COMMUNITY SERVICES DEPARTMENT

October 19, 2022

Subject: Caliber at Woodmoor RM-30 Rezone Review #3 (P-22-014)

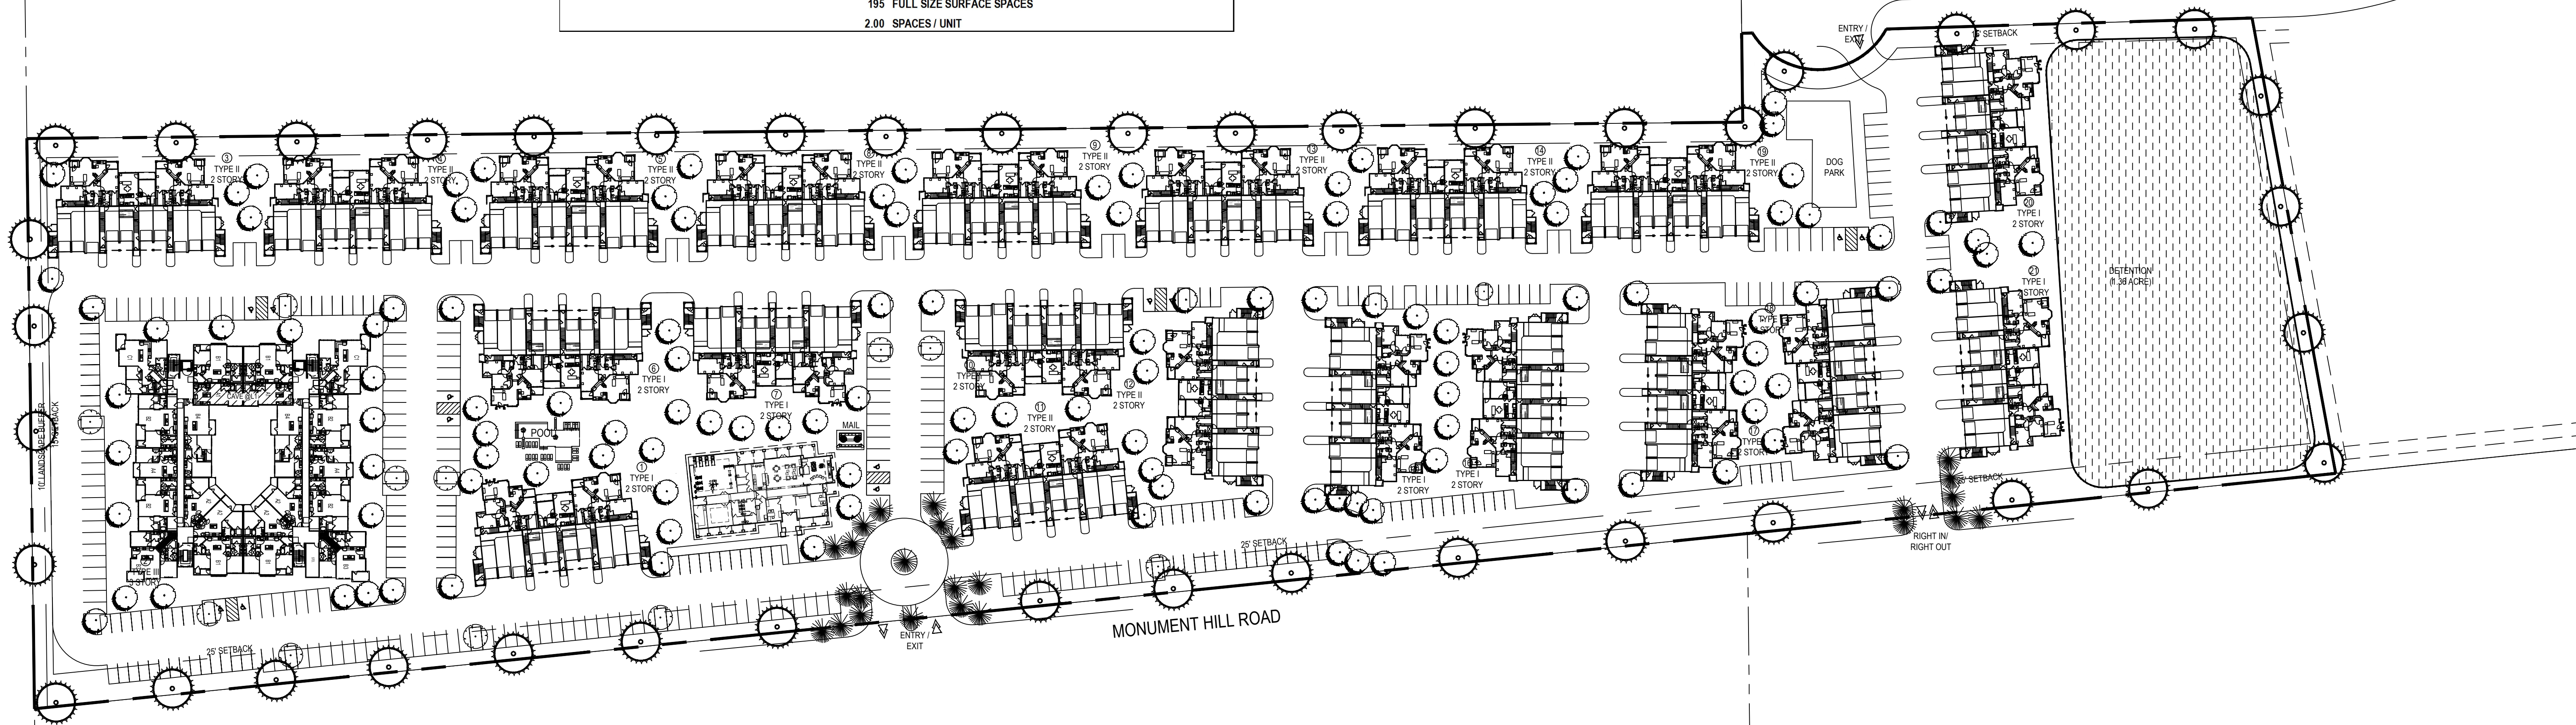
The eDarp Project Description, on the other hand, states the following: *"The Garrett Companies is a national multifamily developer requesting to develop up to 300-350 multifamily units on these two parcels. Conceptually, two site planning options: (1) a **348** unit, all four-story multifamily development that includes surface parking, open space, a clubhouse and full amenity package, and a dog park, (2) a **306** unit, mix of four-story and two-story buildings with the same amenity package."*

Staff requests clarification regarding the number of proposed residential dwelling units at the Caliber at Woodmoor multi-family apartment complex. Furthermore, staff also requests detailed landscape plans for the proposed clubhouses, landscaping, dog park, parks/playgrounds(?), open space areas, and connecting walkways or trails. Staff continues to recommend that the applicant work to connect Caliber at Woodmoor to the nearby Lewis-Palmer Trail system to facilitate safe pedestrian connections to the surrounding community, including nearby businesses and schools (see original comments and recommendations below).
